Examining Authority Written Questions (ExQ2) – Response from City of York Council

Proposal: Application for a Development Consent Order relating to the Yorkshire GREEN Project.  
Applicant: National Grid Electricity Transmission (NGET).

**Planning Inspectorate Reference: EN20024**

Submission Made at Deadline 5  
July 2023

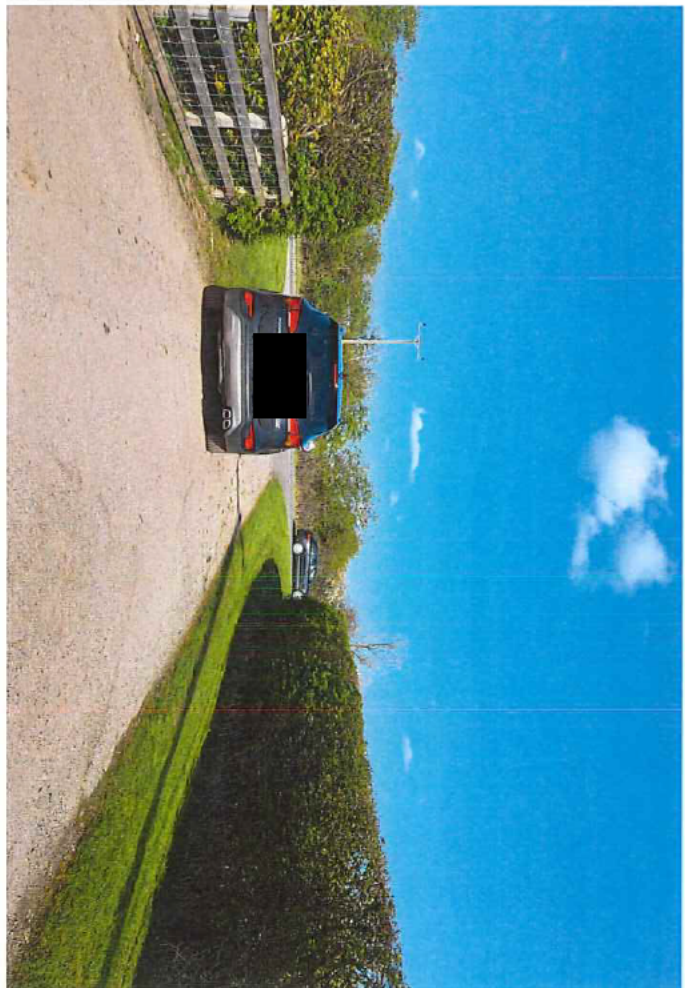
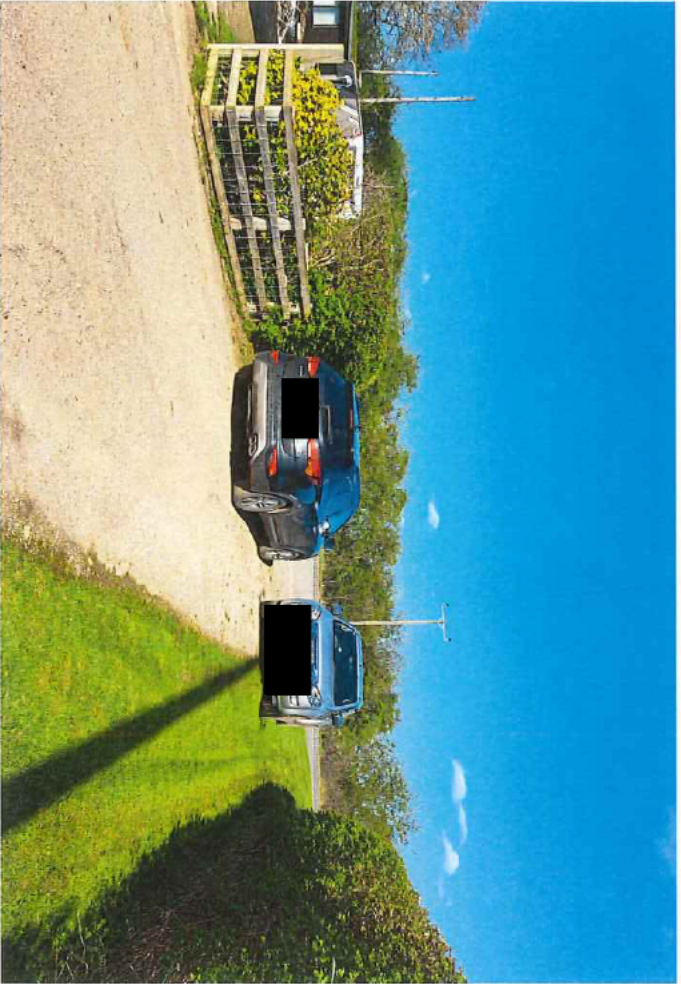
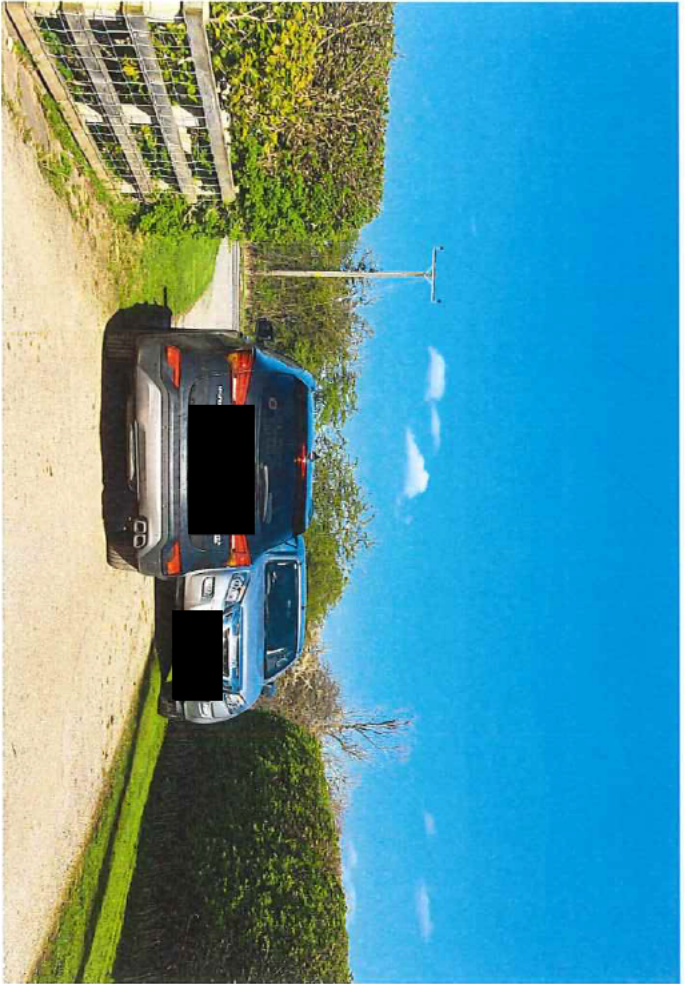
Q14.0.3	<p><b>Highway visibility at proposed alternative access to the north of Skelton Springs Cottages</b></p> <p>At the Accompanied Site Inspection [EV-001b], a potential alternative route to gain access to pylon SP005 was indicated that would be located directly off the A19 to run along the boundary of the field that lies approximately 200m to the north of Access Point 93 and Skelton Springs Cottages.</p> <p>Can the Applicant and City of York Council comment on the acceptability of the visibility splays and any other highway safety matters that would exist should an alternative access point to/from the A19 be undertaken at this location?</p>	<p>CYC Highways advise that it is for the applicant to demonstrate that adequate visibility can be provided at this location.</p>
